**RE: Response Letter to the Review Comments dated May 4, 2020 – O’Reilly Auto Parts,
Colorado Springs, CO.**

GRADING AND EROSION CONTROL PLANS

**1 SITE GRADING PLAN**  
C1.1 SCALE: 1" = 20'-0"

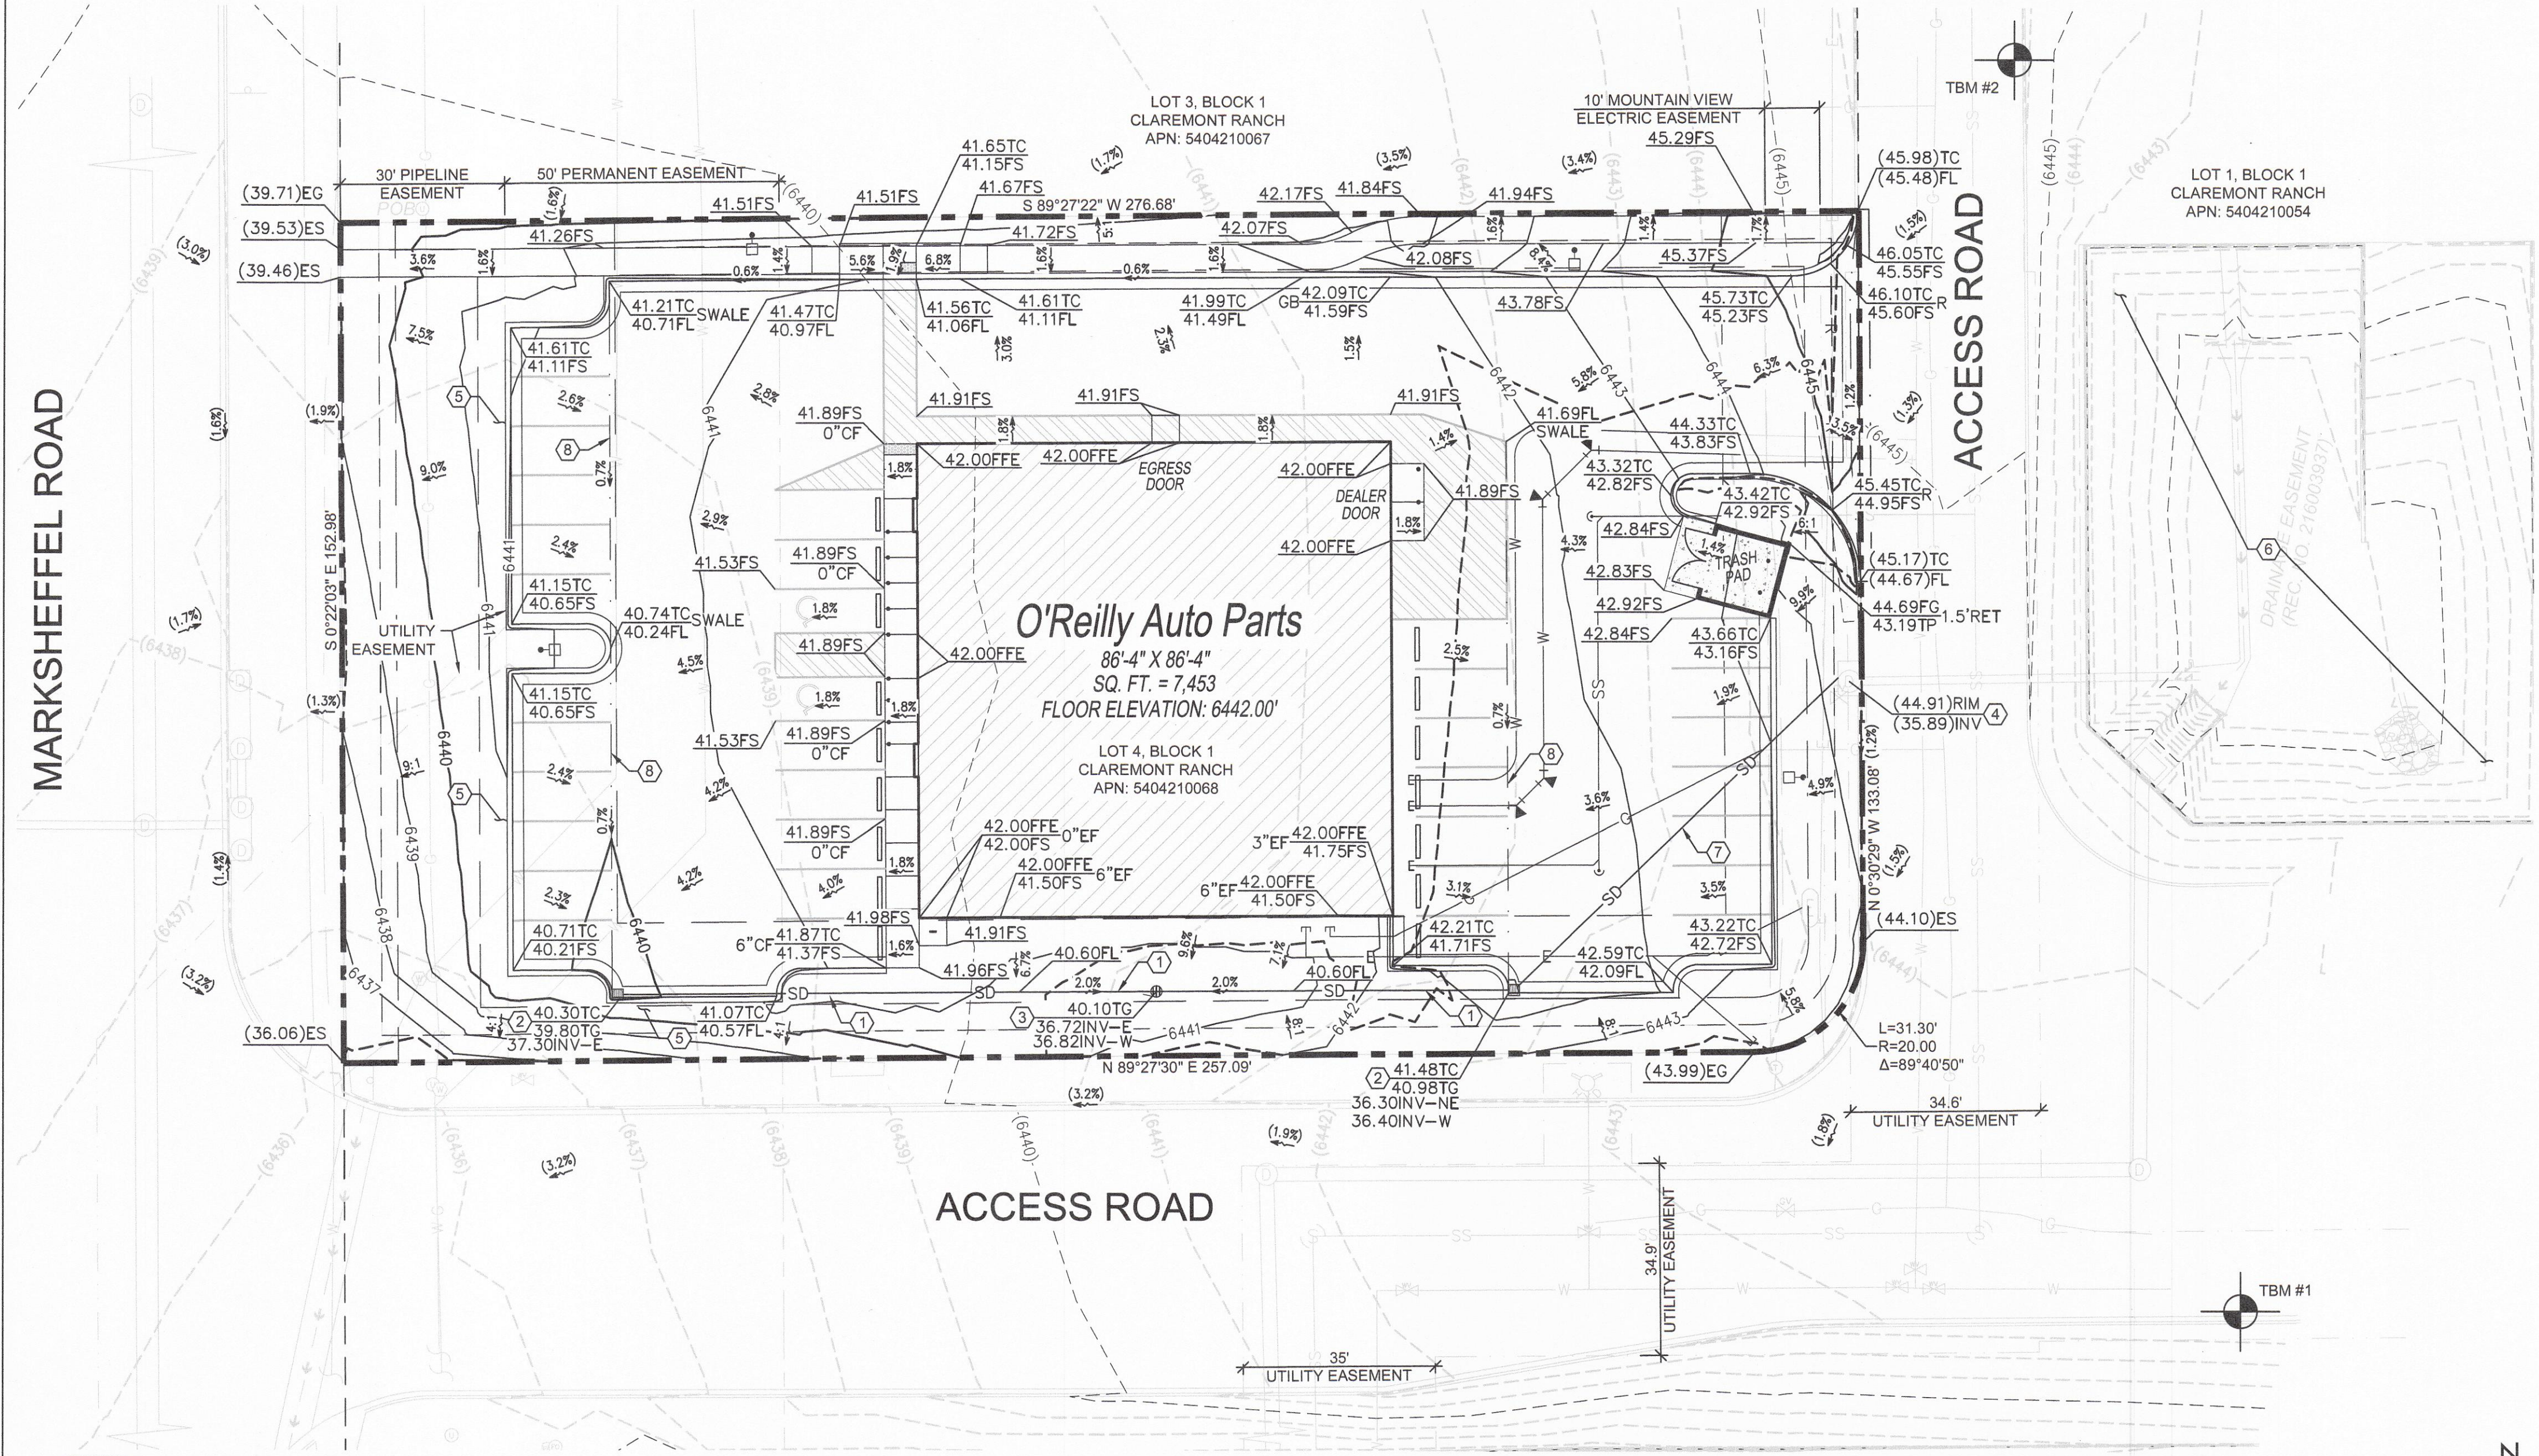
1. Include adjacent city/town/jurisdictional boundaries, subdivision names, and property parcel numbers labeled.
Response: The Subdivision name and property parcel numbers have been added to the Site Grading Plan for the O'Reilly property and adjacent lots.
2. Include existing vegetation (notes are acceptable in cases where there is no notable vegetation, only grasses/weeds, or site has already been stripped).
Response: An existing vegetation note has been added to Sheet C1.2 Site Erosion Control Plan.
3. Include all proposed temporary construction control measure details. Custom or other jurisdiction's details used must meet or exceed EPC standards.
Response: All applicable temporary construction details are shown on Sheet C1.4. The VTC detail has been updated to meet EPC standards.

COMM #	4369
DATE:	10-11-19
REVISION DATE:	02-26-2020
	05-28-2020

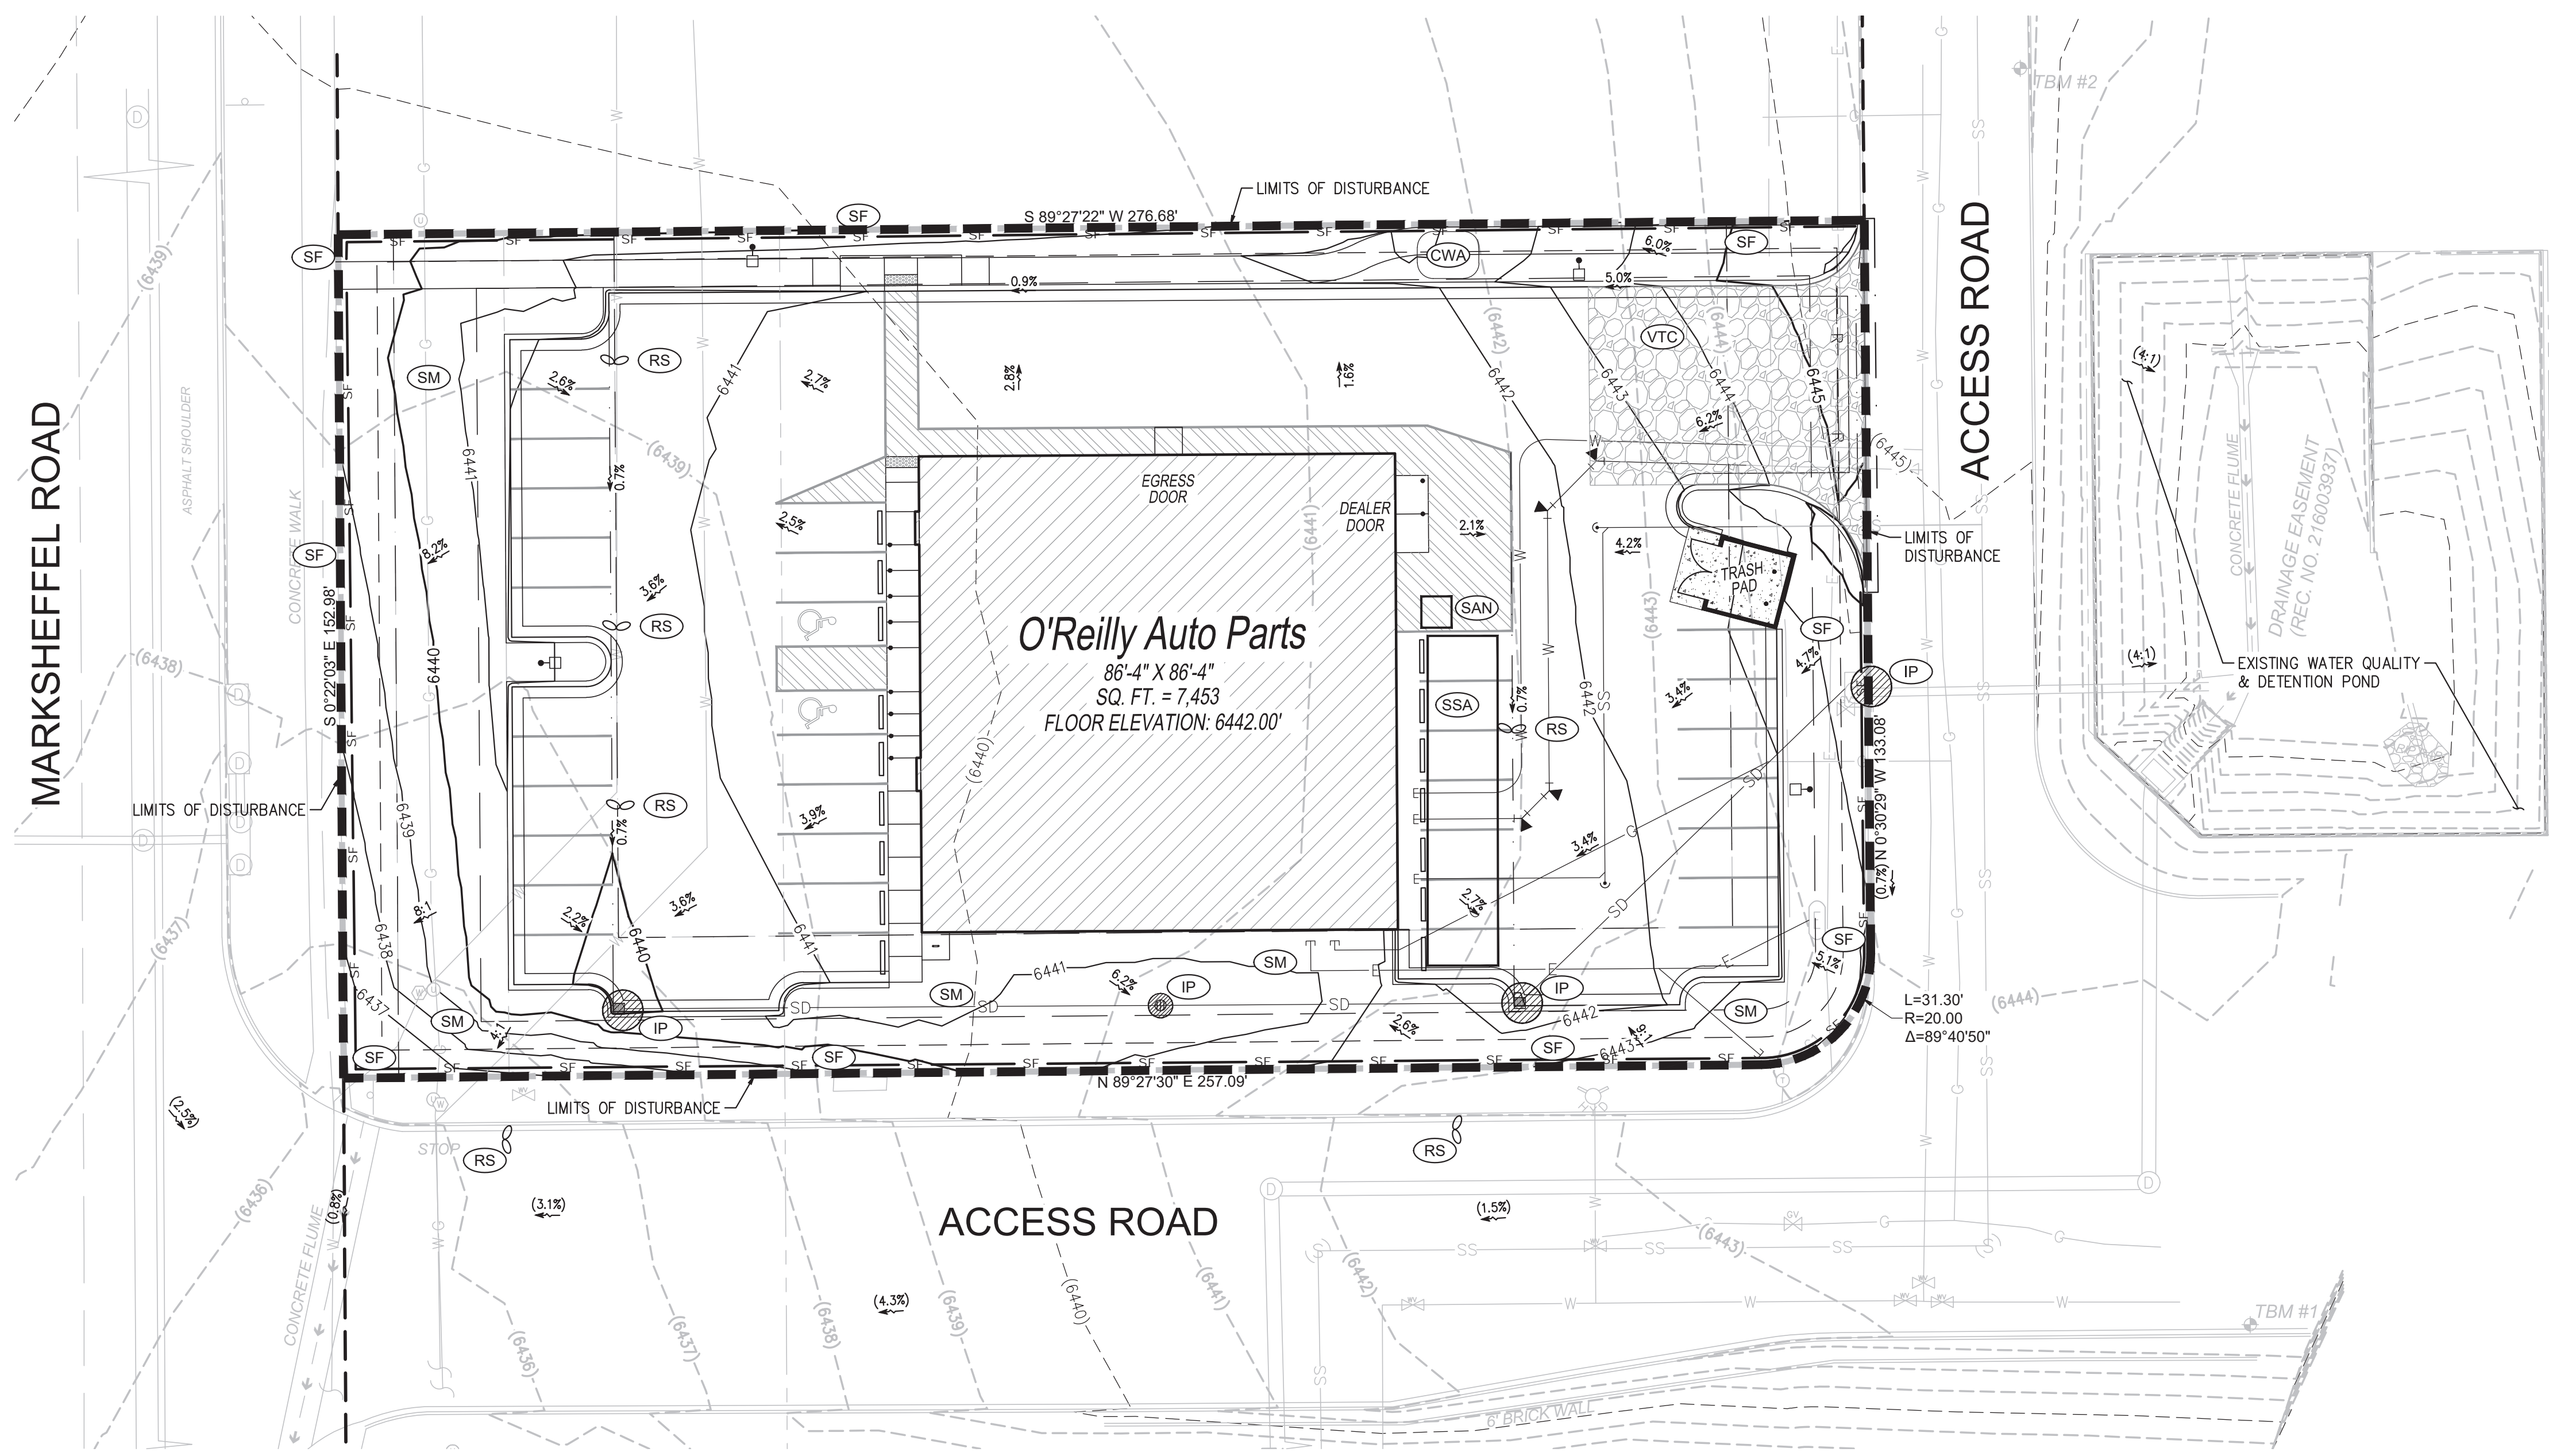
Response: A statement has been added to Sheet C1.2 and the SWMP stating that there will be no dedicated asphalt/concrete batch plants.

Response: A statement has been added to Sheet C1.2 and the SWMP stating that there are no springs, streams, wetlands, and other surface waters near the site.
